Application No: A/71/21/HH  
Site Address: Rond Point Ham Manor Way Angmering BN16 4JQ  
Description of works: Erection of new fence adjacent to front boundary.

Thank you for your internet representation made on 14th May 2021 which has been recorded as an objection with the comments as follows:

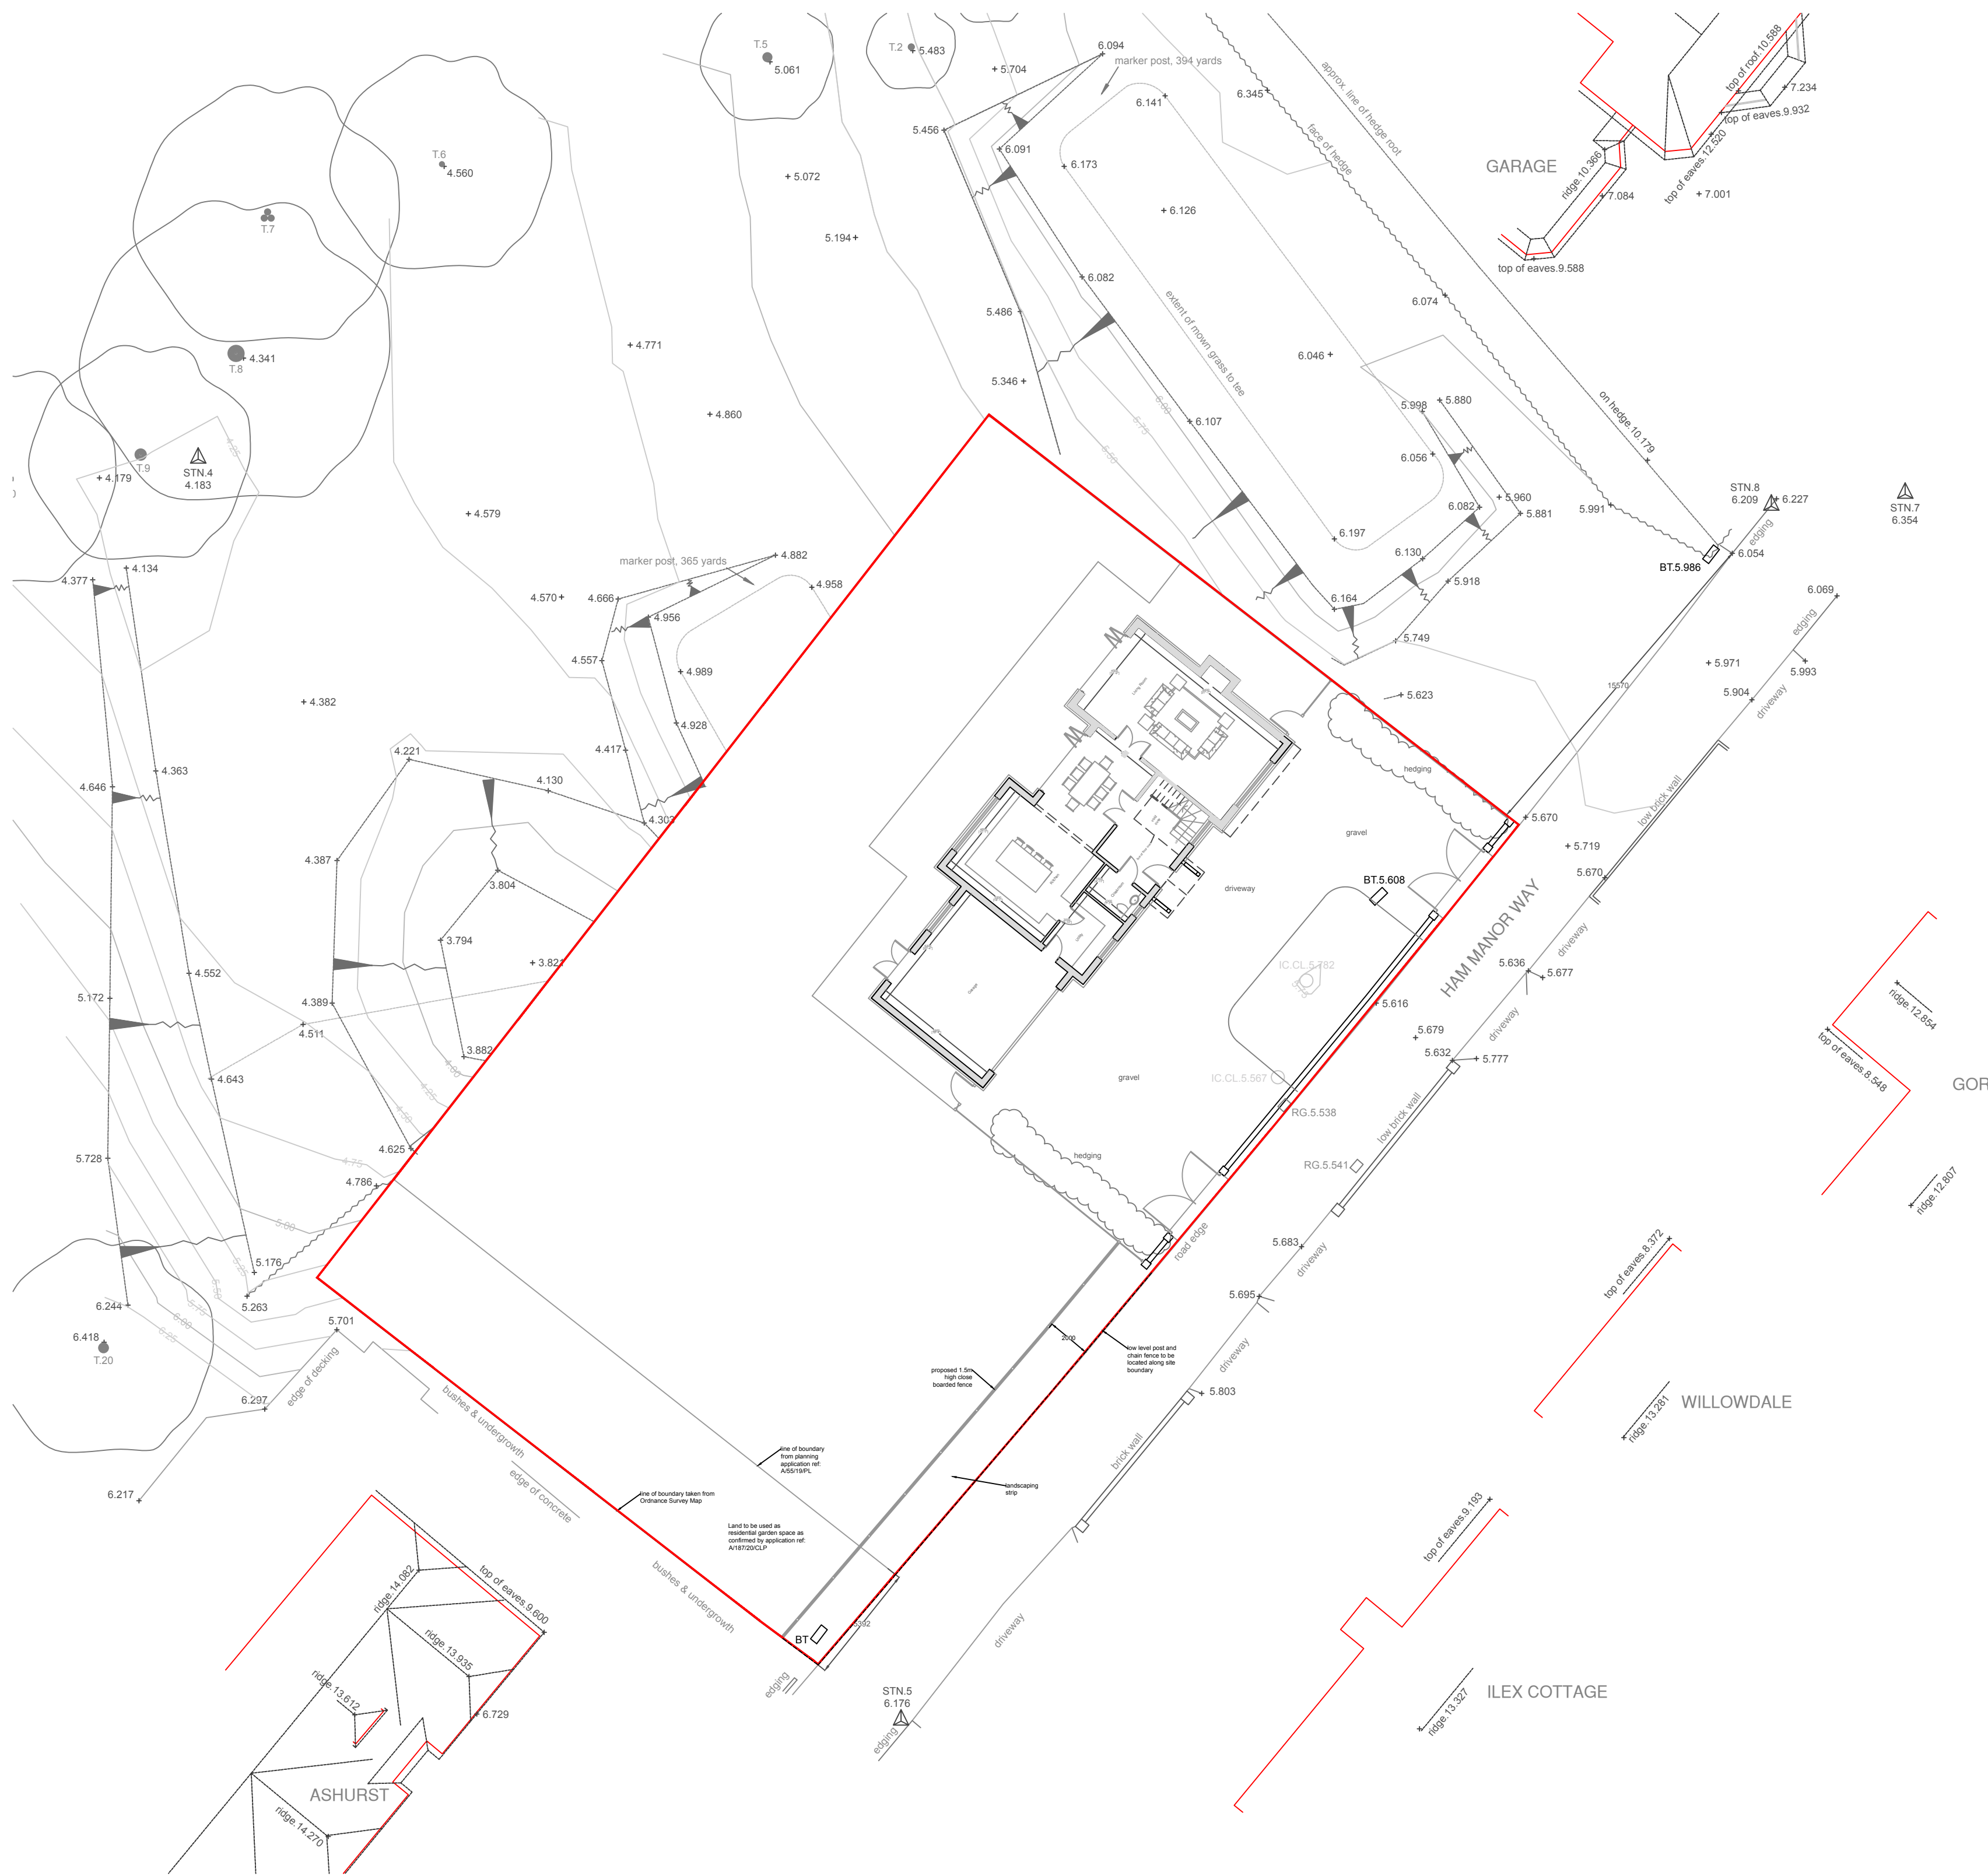
It is recognised that a similar side garden fence exists on the front boundary to Ham Manor Cottage which is further south on the east side of Ham Manor Way. However, there are no further houses immediately adjacent to the south of it, and the overall street scene is not affected.

The houses immediately adjacent this new dwelling, and others along this length of the road, all have open style frontages. In order to preserve this characteristic and the street scene, it is considered that the proposed fence, which gives privacy to the side garden, should be set further back from the front boundary to line up with the front elevation/face of this new dwelling.

It is noted that some fencing has already been erected in the front garden and it is unclear whether planning permission exists for this.
